Recommendation Report for Planning Permission for Works or Extension to a Dwelling

REF NO: LY/6/21/HH

LOCATION: 1 The Paddock
Lyminster
BN17 7QH

PROPOSAL: Erection of single storey front and rear extensions and internal alterations. This application affects the character and appearance of the Lyminster Conservation Area.

1 PROPOSED EAST ELEV.
1 : 50

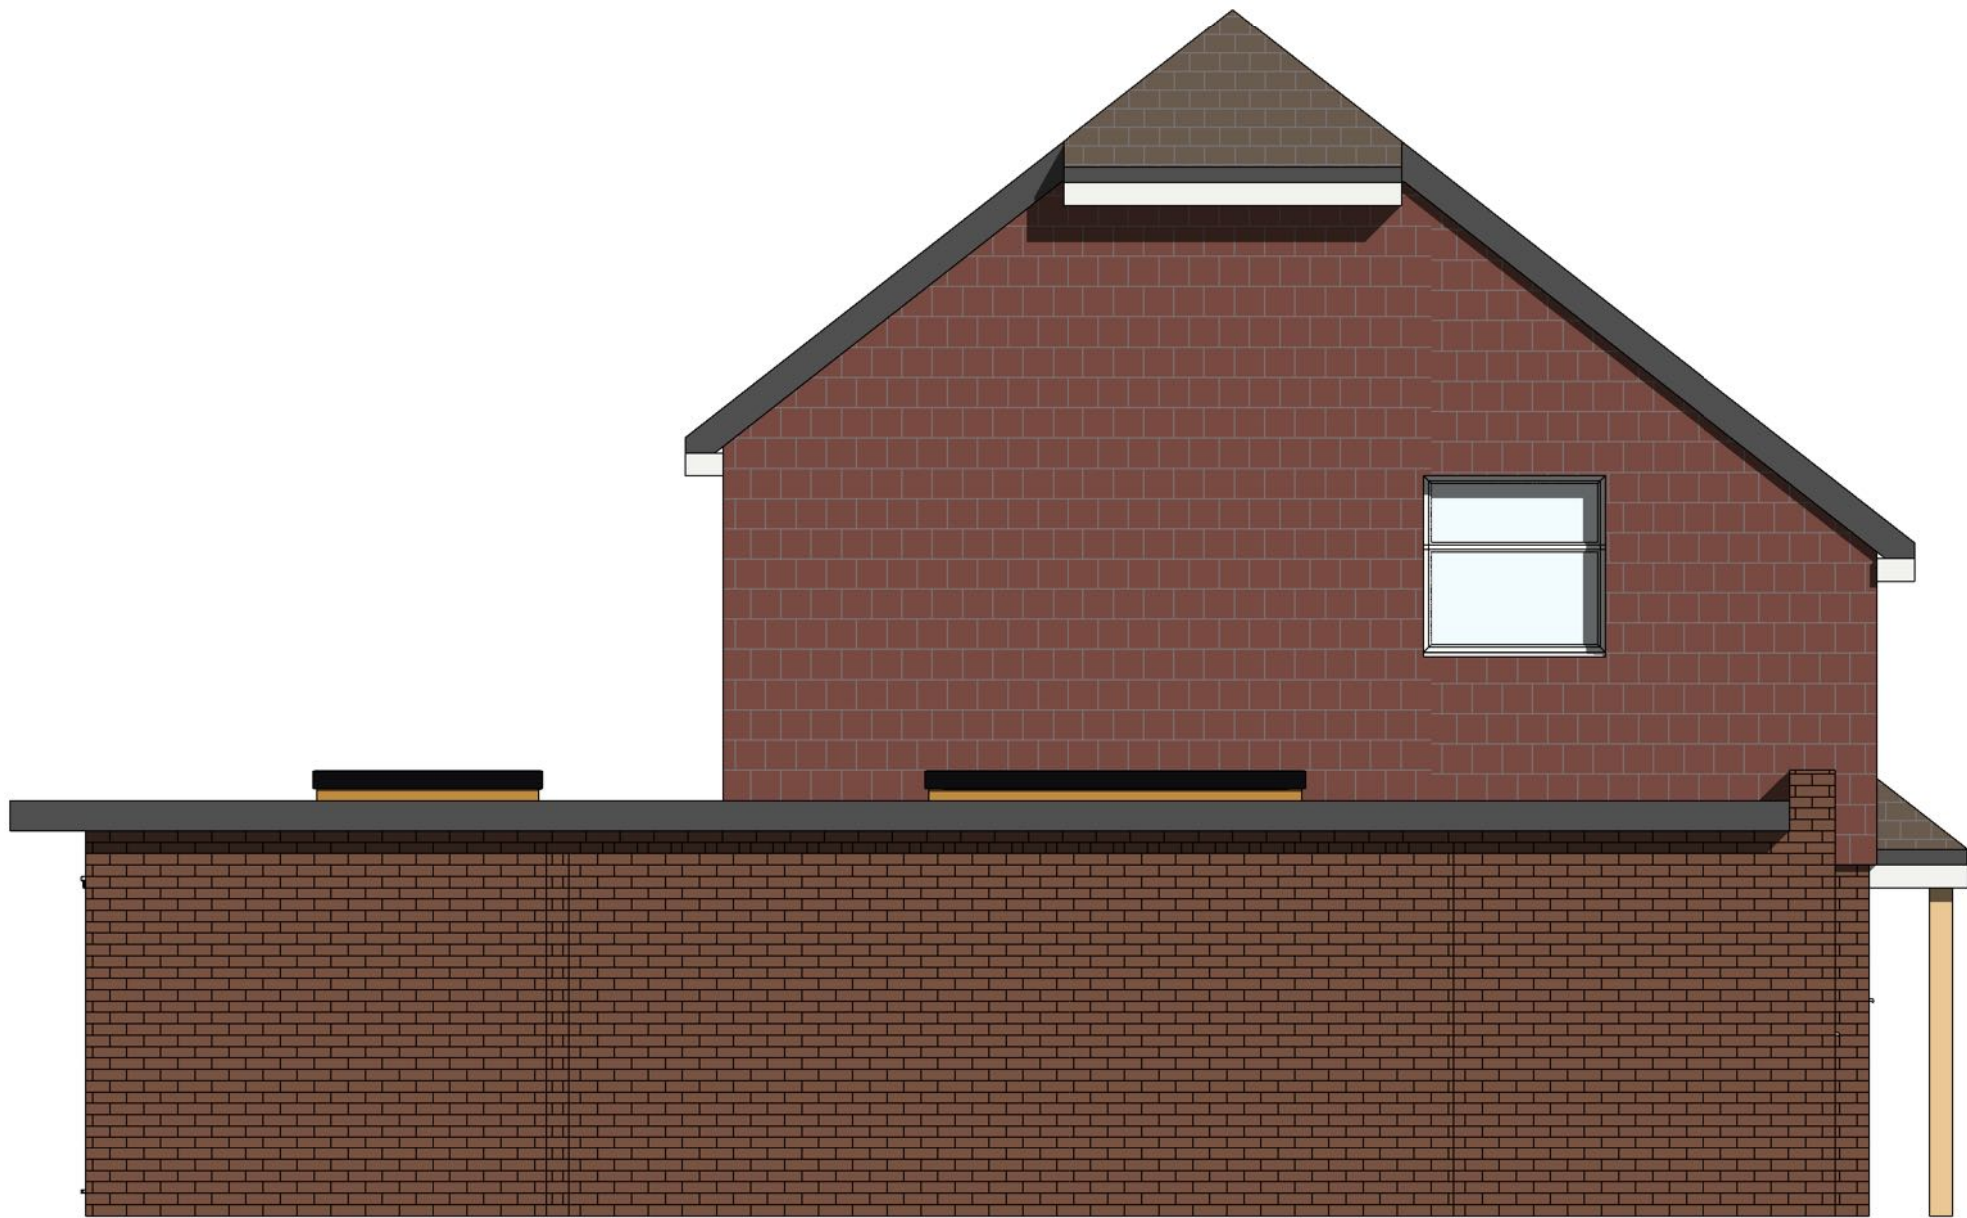
Arun District Conservation Area Advisory Panel - No Objection. The appearance of the top of the front extension could be improved with say the use of a brick soldier course or brick corbelling rather than the stretcher bond shown on the drawings.
